Online Comment

Application H23-0086-25
Location THE MELROSE DOWSDALE BANK SHEPEAU STOW PE12 0TZ
Proposal Extension to building 1 to provide four additional kennels and erection of new building to provide 10 kennels. Cessation of dog training.

Name Diane Gordon
Address SHDC Environmental Protection

Date Submitted 04-03-25
For/Against Objections

Project:	Kennels, The Melrose Dowsdale Bank, PE12 0TZ	
Drawing Title:	Location and Block Plan As Proposed

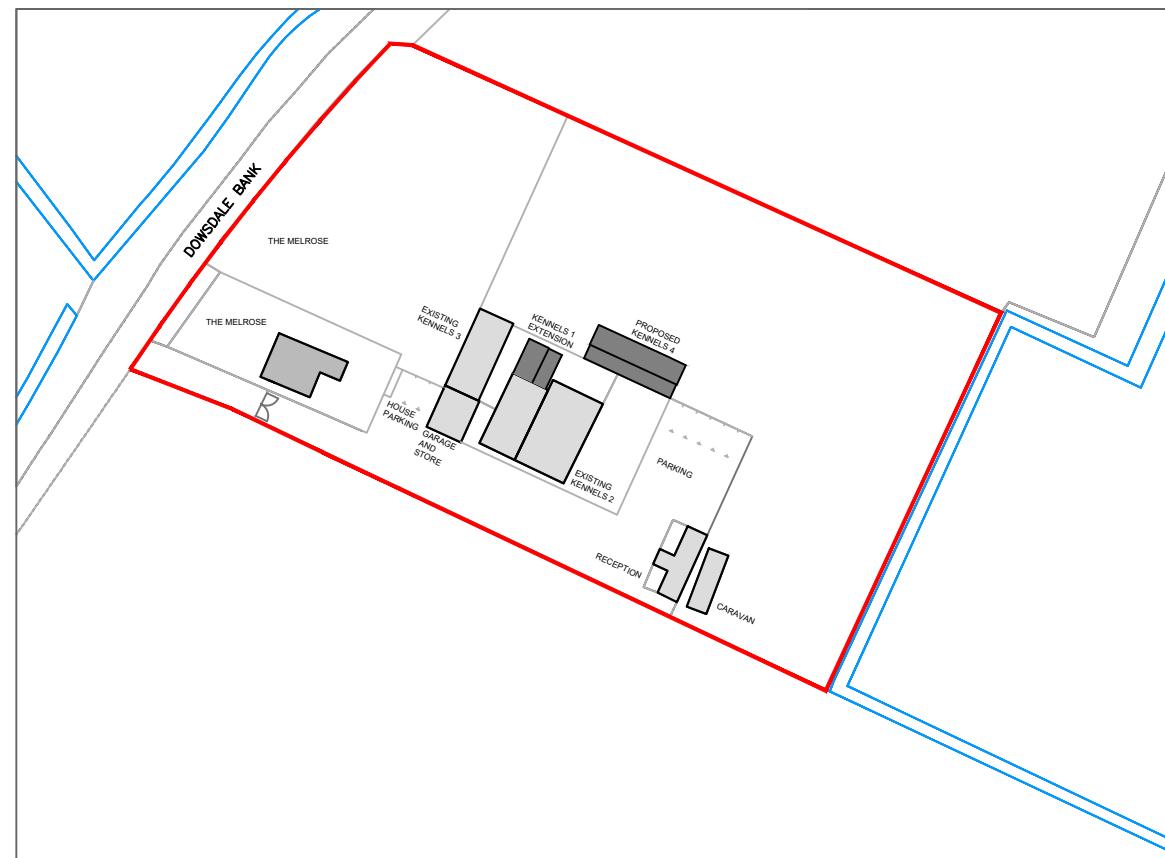
details of site boundary fencing and construction of kennels.
